REQUEST

Current Zoning: R-3 LWPA (single family residential, Lake Wylie Protected Area)
Proposed Zoning: MX-2 Innov LWPA (mixed use, innovative, Lake Wylie Protected Area)

Approximately 43.72 acres located on the south side of Mt. Holly-Huntersville Road and north side of Interstate 485, west of Oakdale Road.

The petition proposes a residential community containing a maximum of 313 residential units. The unit mix could consist of single family detached and/or single family attached dwelling units and /or multi-family attached (triplexes) dwelling units with innovative standards.

RZP-2022-089

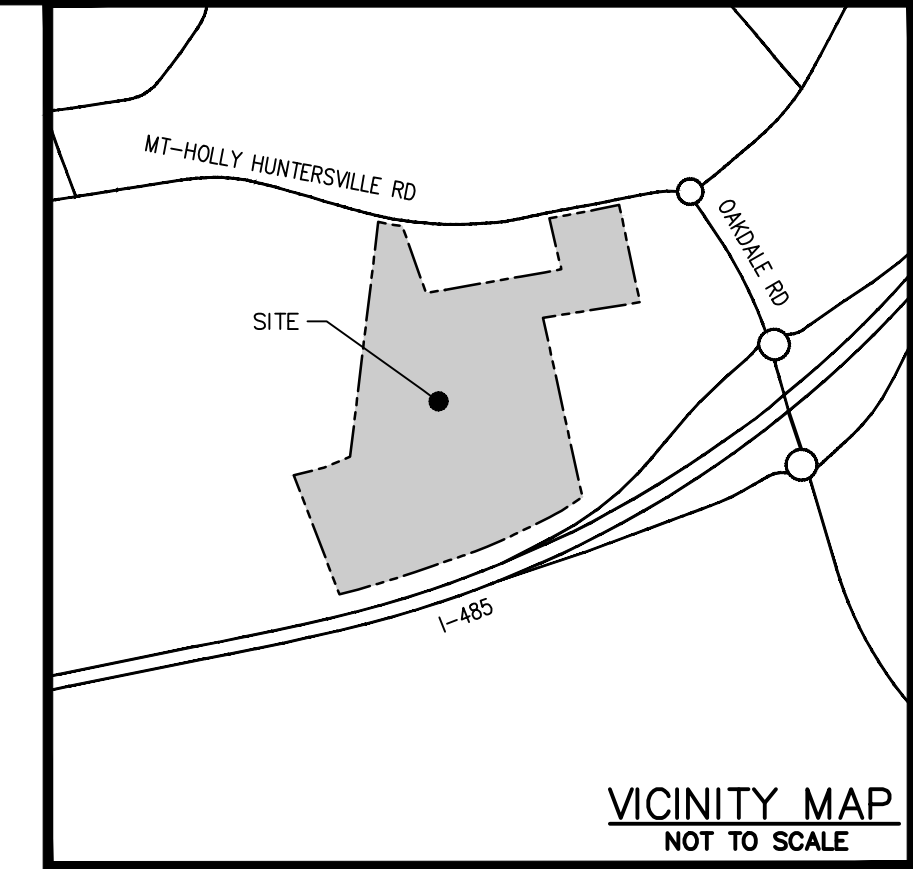
1. Add a conditional note committing to the construction of each public roadway. Identify each roadway as U-03 on the site plan and in the conditional note.
2. Site plan and conditional note revisions are needed to show turn lane improvements. The site plan shall label and dimension the components of the turn lane. Add a conditional note committing to the turn lane improvements. Coordinate with NCDOT on turn lane storage length requirements.
3. A site plan notes specifying that all transportation improvements will be approved and constructed before the site's first building certificate of occupancy is issued as needed. The petitioner may phase transportation improvements if said improvements and phasing are explicitly described in site plan notes.

5. Revise site plan to construct a 12-foot multi-use paths on Mt Holly Huntersville Road. The site plan shall label and dimension both items from the back of curb and gutter and road centerline. The entire facility must be outside of the right of way and within a public access easement. Add conditional note committing to construction and maintenance of the 12-foot multi-use paths on Mt Holly Huntersville Road.

6. Remove garages.
